Our Ref: BR/116/19/L

Application for Listed Building Consent for Alterations, Extension or Demolition of a Listed Building

Development Installation of car park management system (ANPR system and associated signage)
Location The Royal Norfolk Hotel The Esplanade Bognor Regis

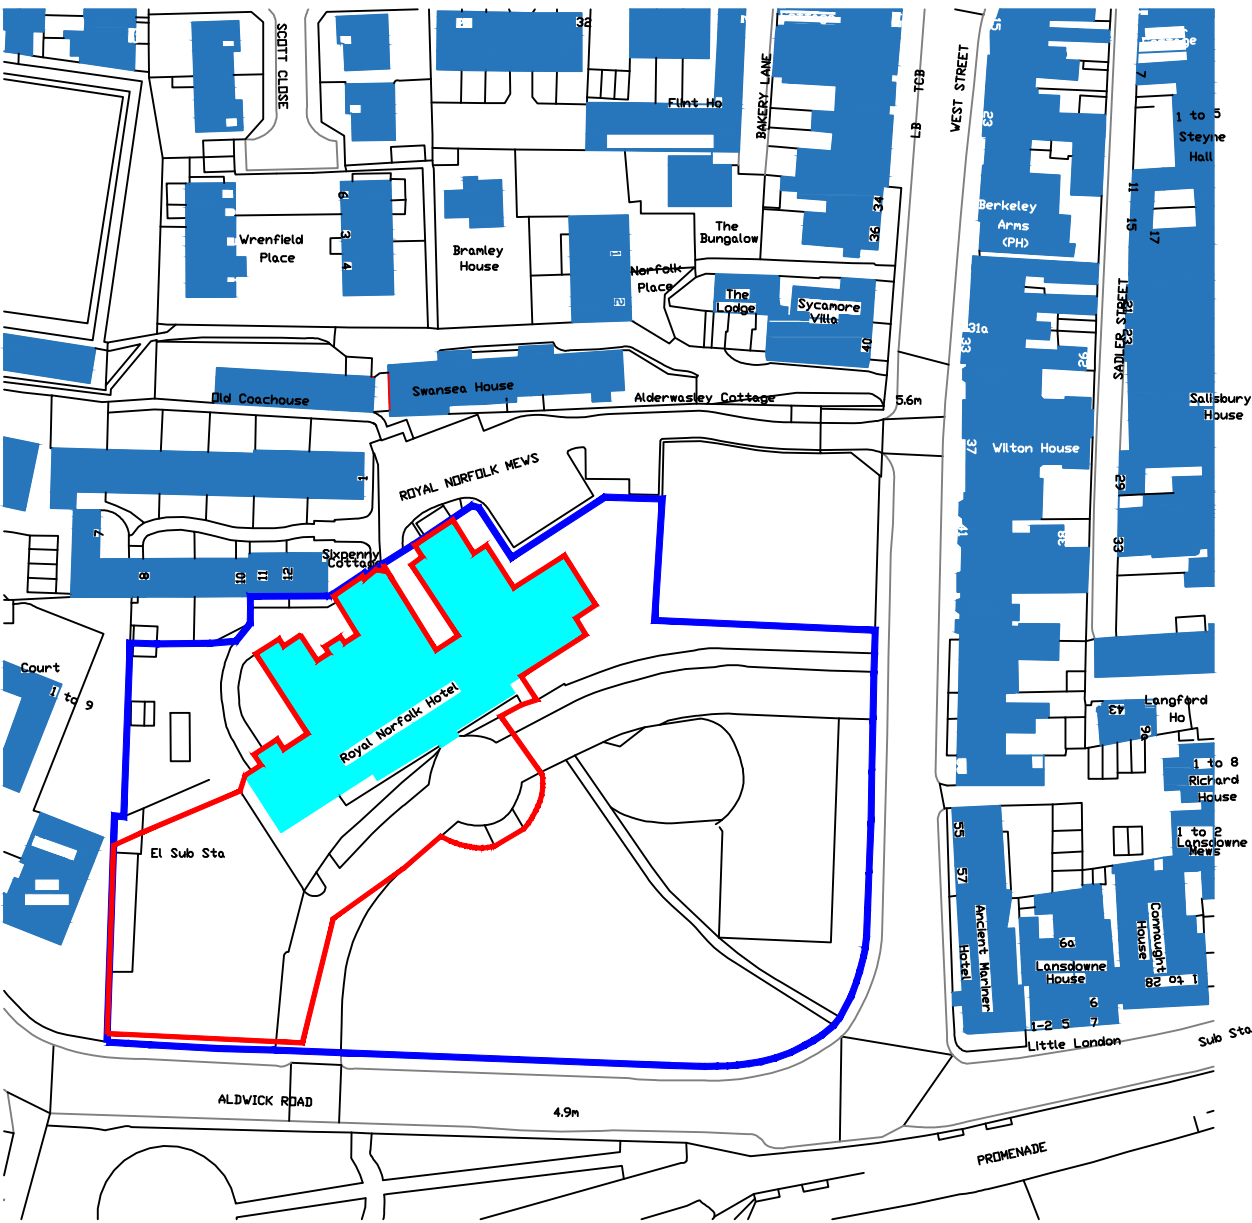
Location Plan: Please include the Royal Norfolk Hotel within the red outline on the location plan and remove all other red outline on the plan on the surrounding properties.
